## **Great North Road Solar and Biodiversity Park**

Draft Statement of Common Ground with Nottinghamshire County Council

Document reference – EN010162/APP/8.1

December 2025

0 0.25 0.5 1 km

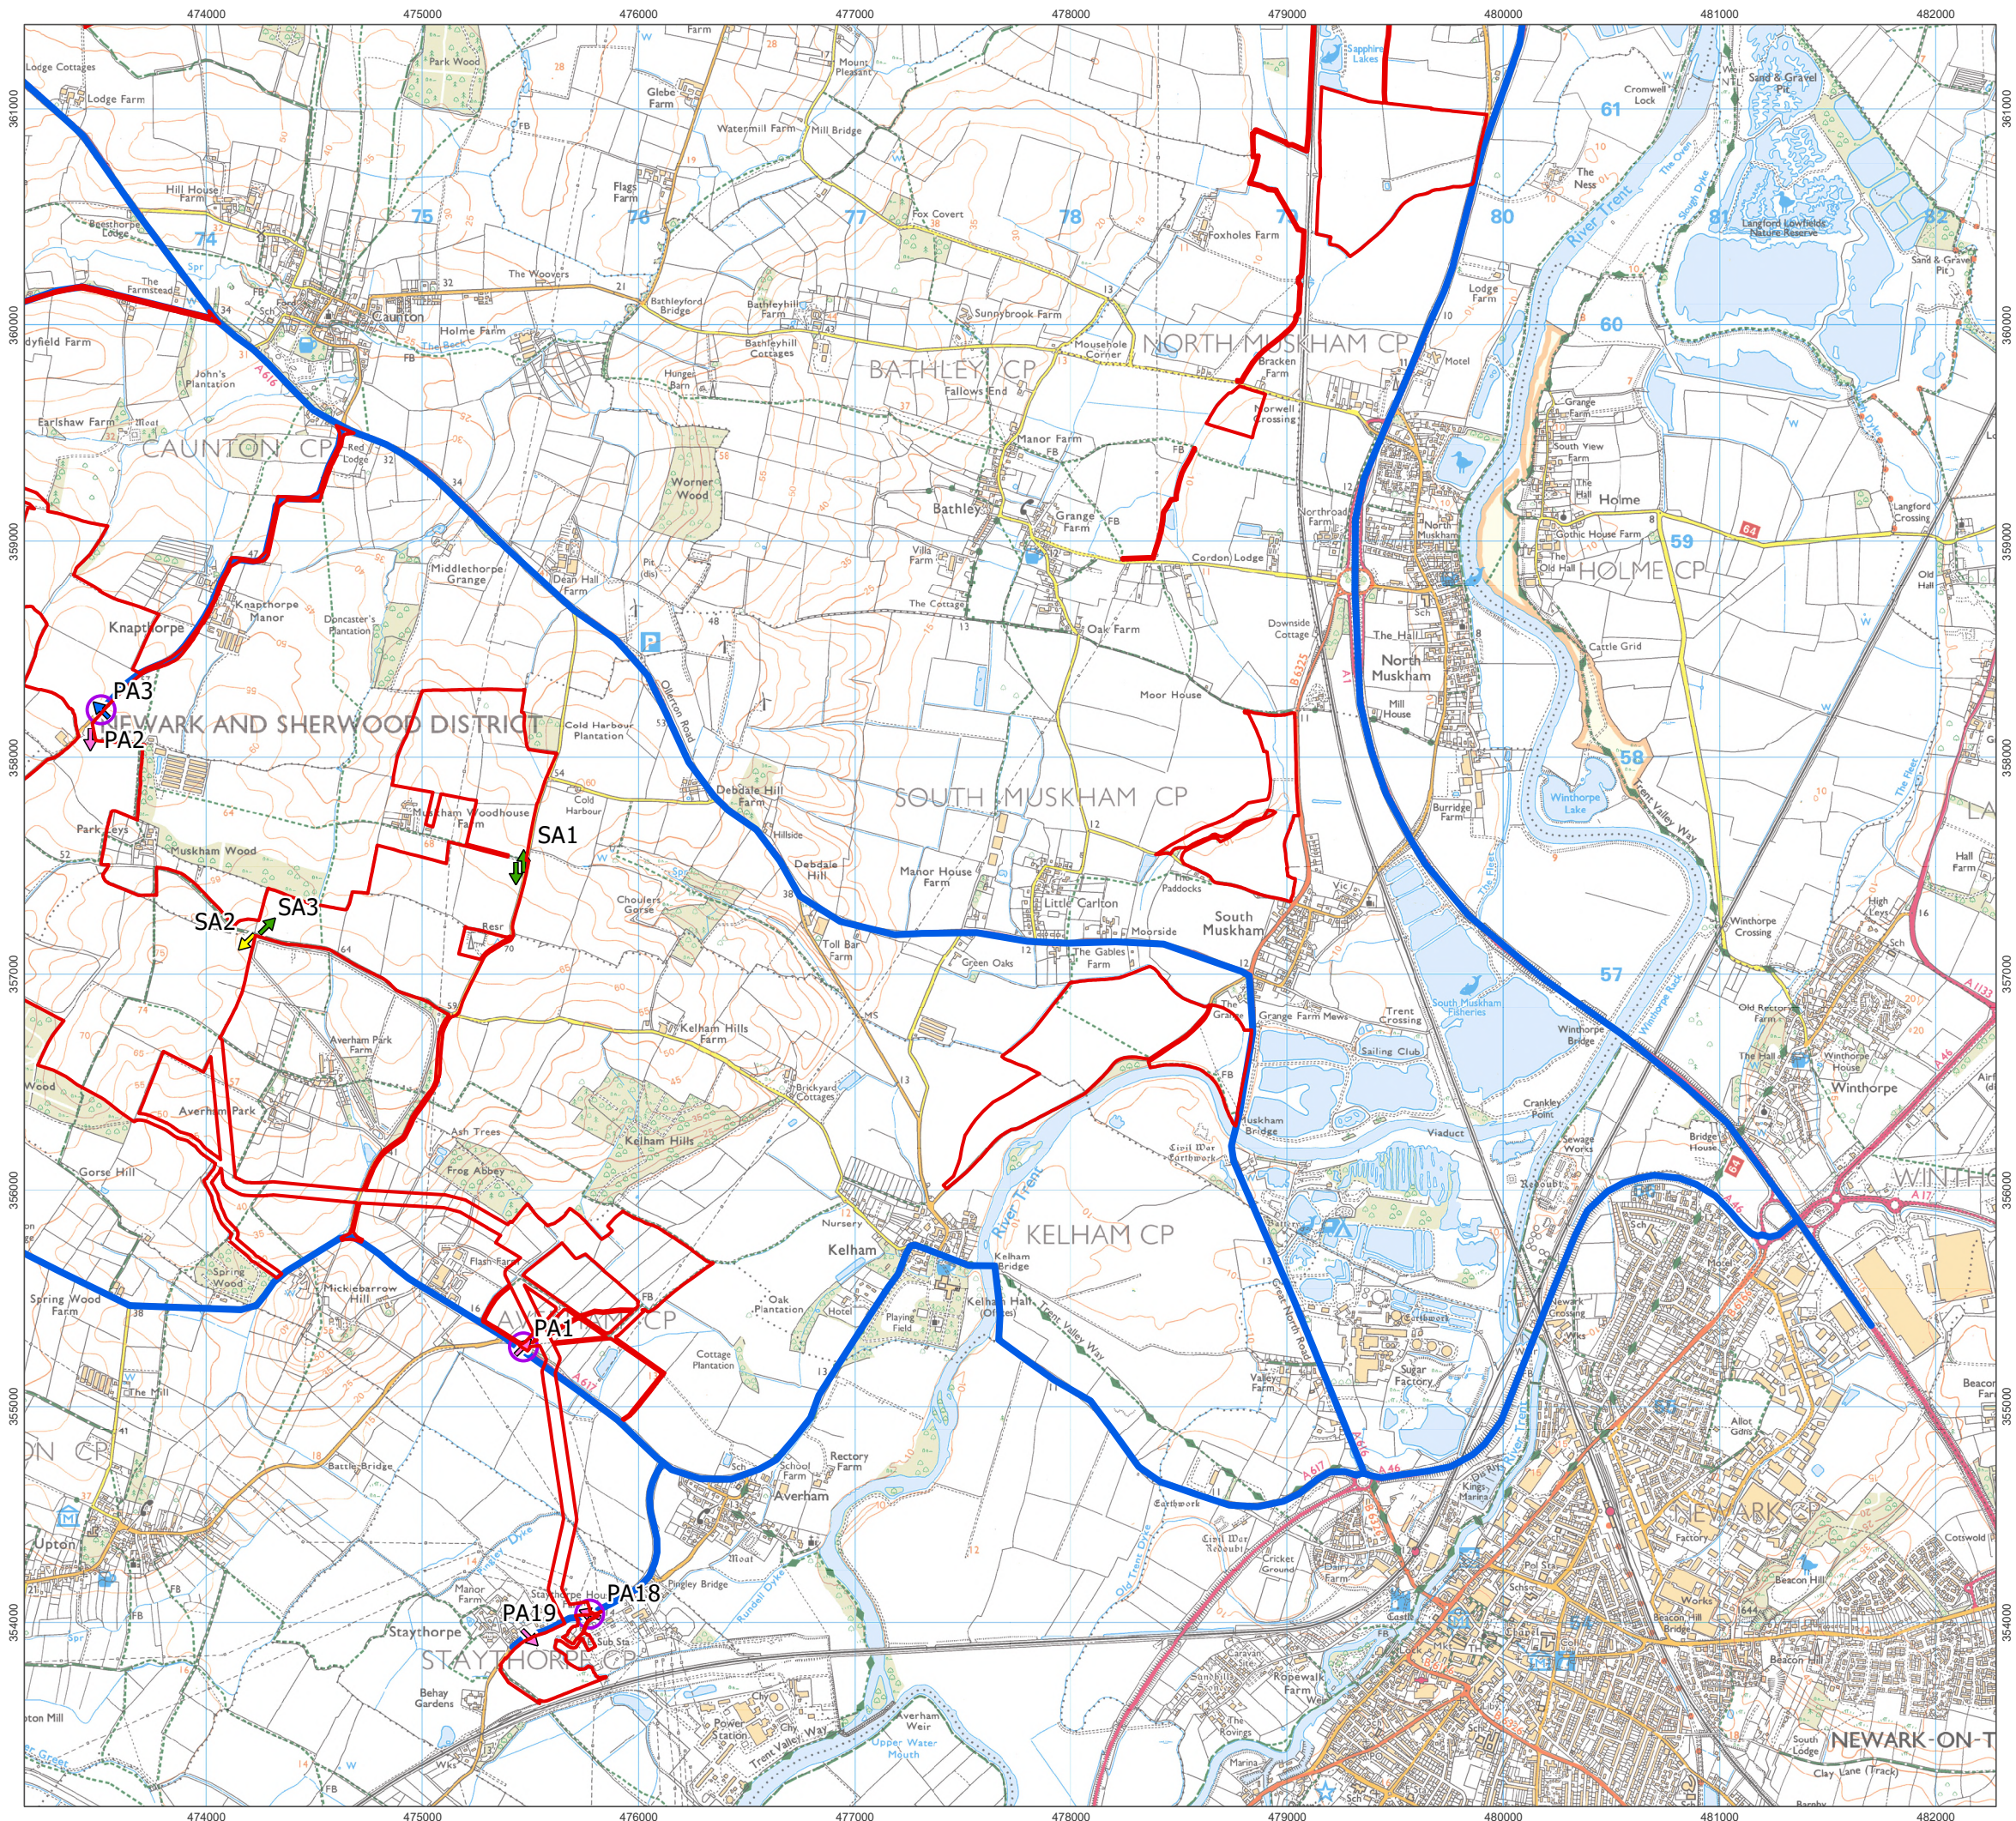
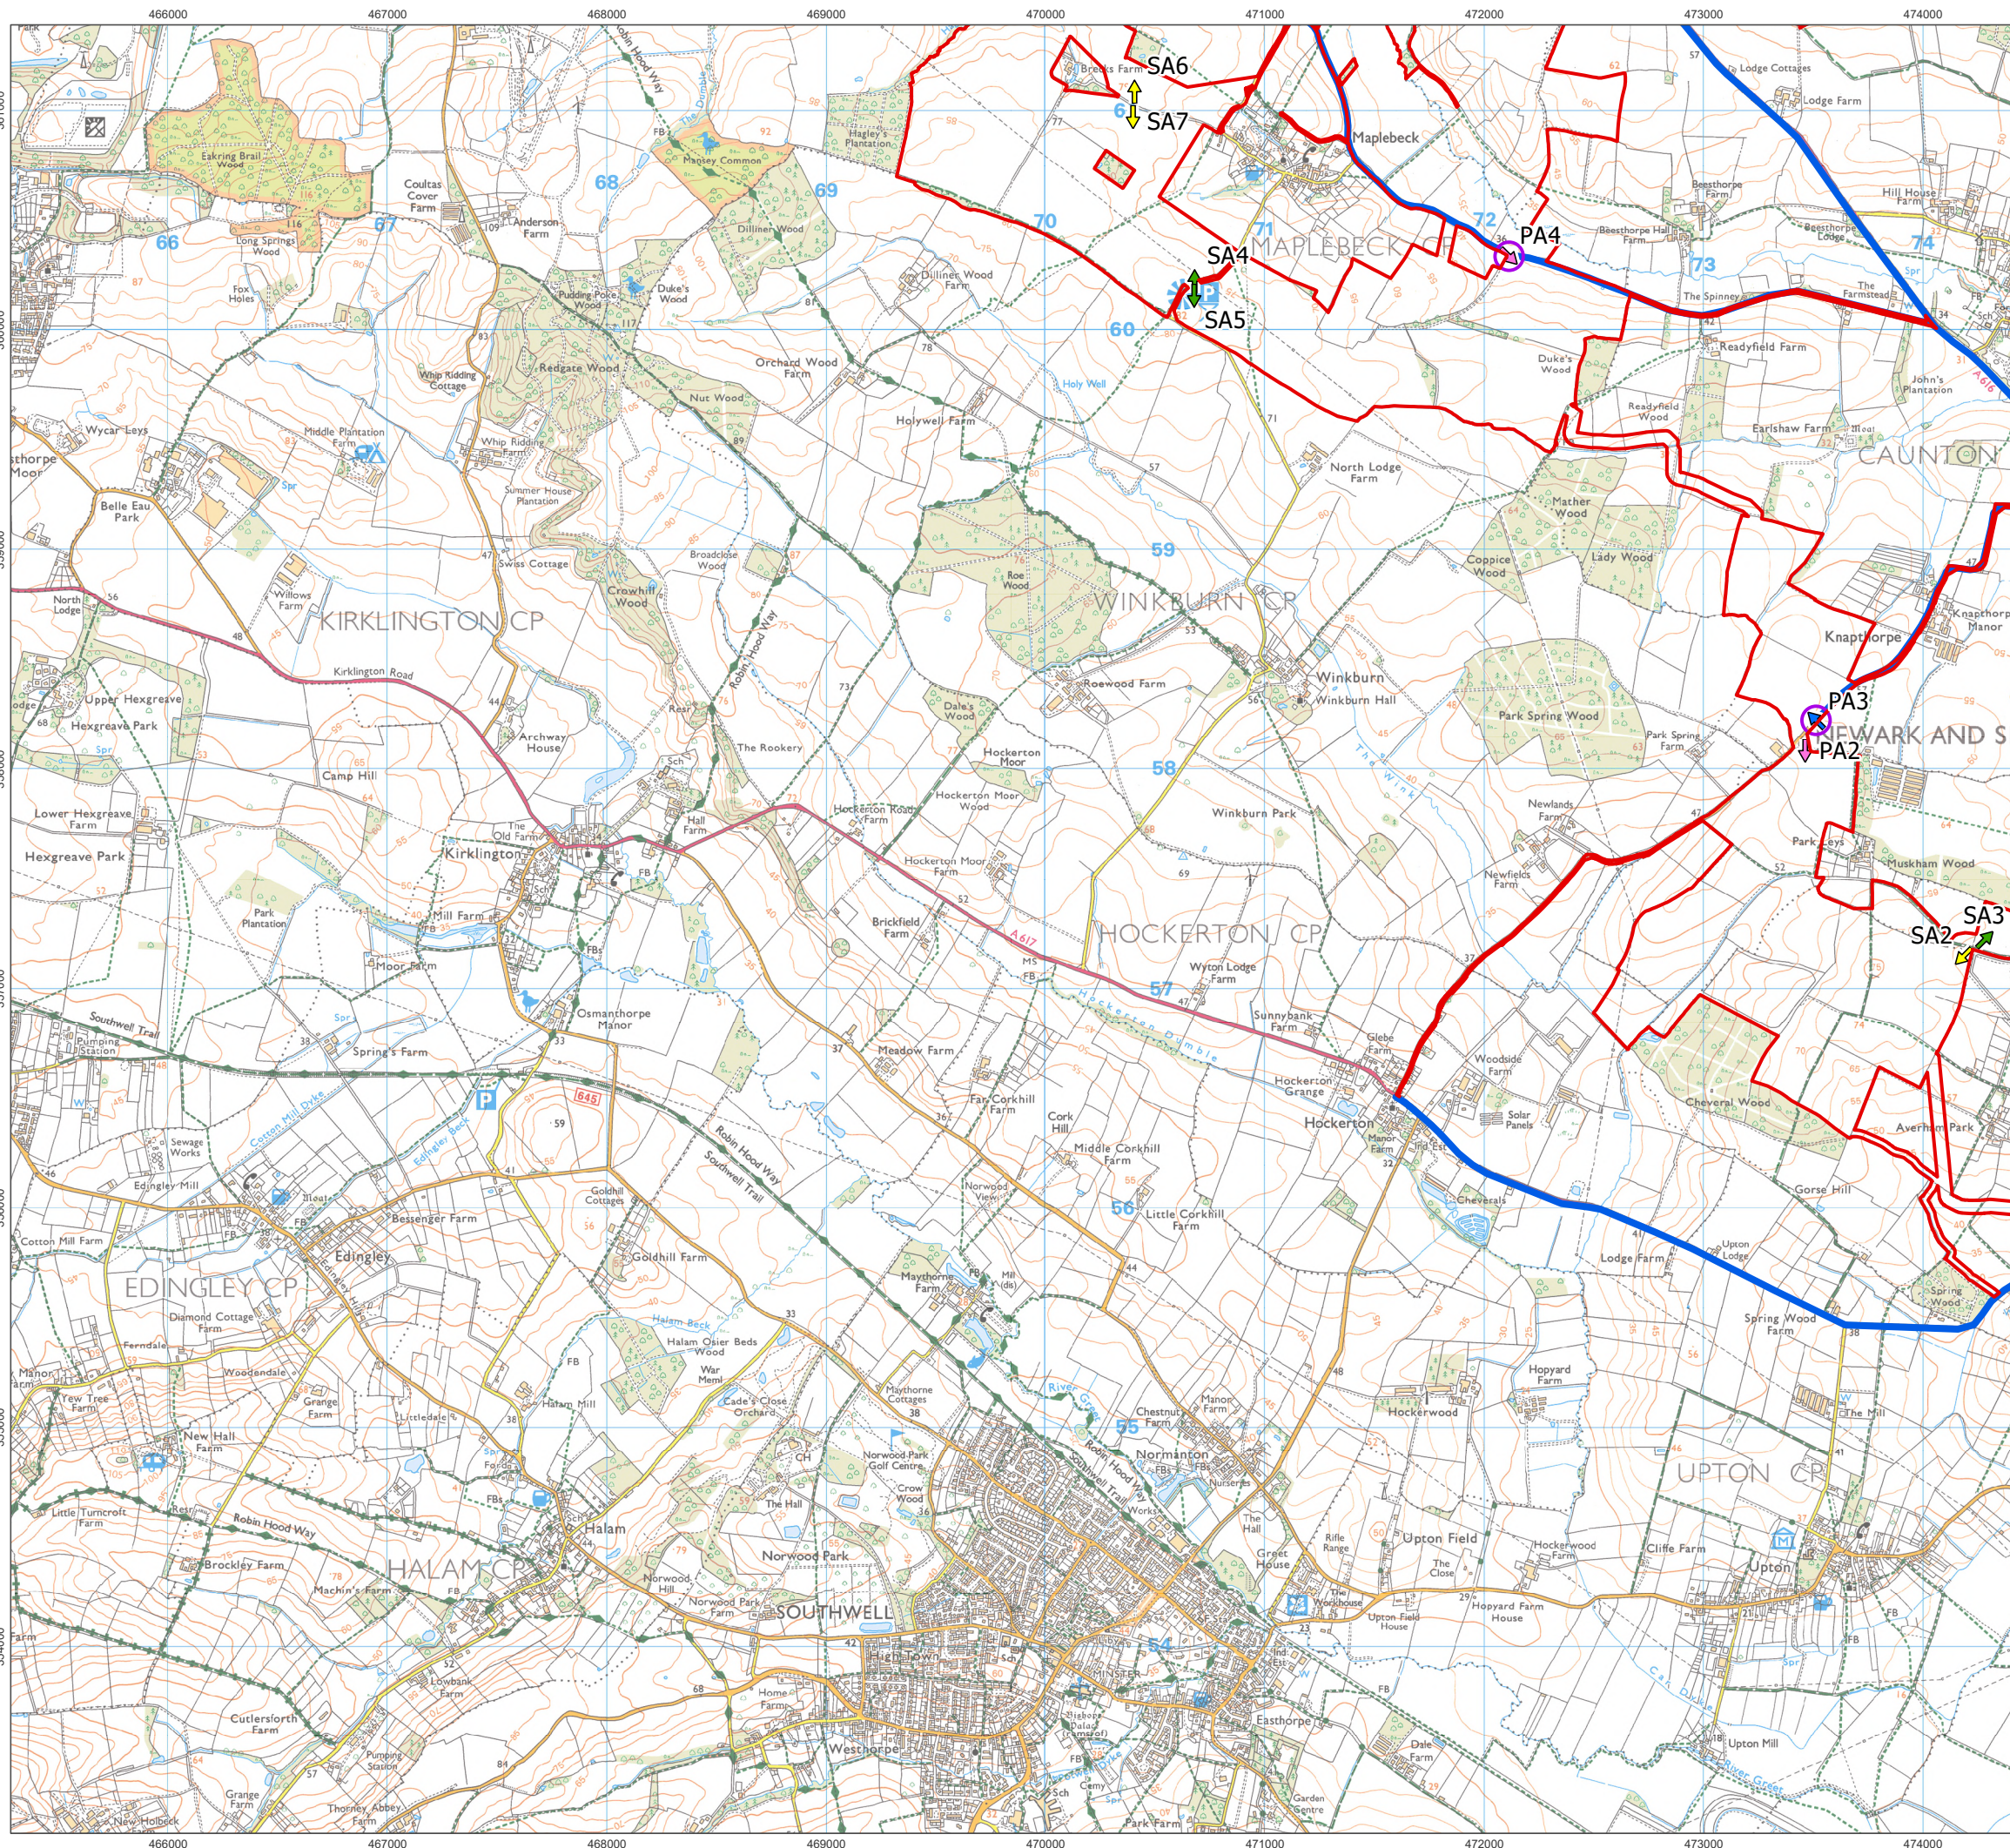
2.5.8	RR	Accesses	<p>The Access Routes Hierarchy is shown in <b>ES Volume 3, Figure 5.1: Works Areas</b> [EN010162/APP/ 6.3.5B]. The</p>	<p>No consideration to the form of access appears to have been given. The traffic information supplied identifies that a number of the accesses trigger the</p>	Under Discussion

Ref	Document Reference	Description of Matter	Applicant's Position	NCC's Position	Status
			<p>Site Access locations are then shown at <b>ES Volume 3, Figure 14.4: Site Access Locations [EN010162/APP/6.3.14A]</b> and <b>ES Volume 3, Figure 14.5: Passing Place Locations [EN010162/APP/6.3.14A]</b>.</p> <p><b>ES Volume 4, Appendix A14.1: Transport Statement [EN010162/APP/6.4.14.1A]</b> Appendix D. provides the site access designs, including their form, key dimensions and demonstrates their suitability through swept path analysis of the largest anticipated HGV entering and exiting each respective location.</p> <p>This analysis of the construction access points confirms that they can be designed to meet relevant design standards.</p> <p>The Applicant will engage with NCC (the Local Highway Authority) to provide any further information, including the</p>	<p>requirement in DMRB CD123 for further assessment, during both the construction and operational phase. Where only occurring in the construction phase, mitigation in the form of traffic management may be acceptable, but locations where this would be required should be identified.</p> <p>Information regarding the number of HGVs at each access was requested, and whilst information in Appendix F provides a breakdown, it is difficult to link the accesses in here to those described elsewhere and therefore clarity is required.</p> <p>Whilst a statement is made that the access drawings are outline drawings and detailed designs will be forthcoming at the appropriate time, the principle of acceptability needs to be established. There are a number of accesses, either proposed or amended (with increased usage) which have</p>

Ref	Document Reference	Description of Matter	Applicant's Position	NCC's Position	Status
			requirements for a Road Safety Audit.	apparent highway safety concerns. All new or amended accesses should therefore be subject to a Stage 1 Road Safety Audit, as required by the Nottinghamshire Highway Design Guide, to inform this process.
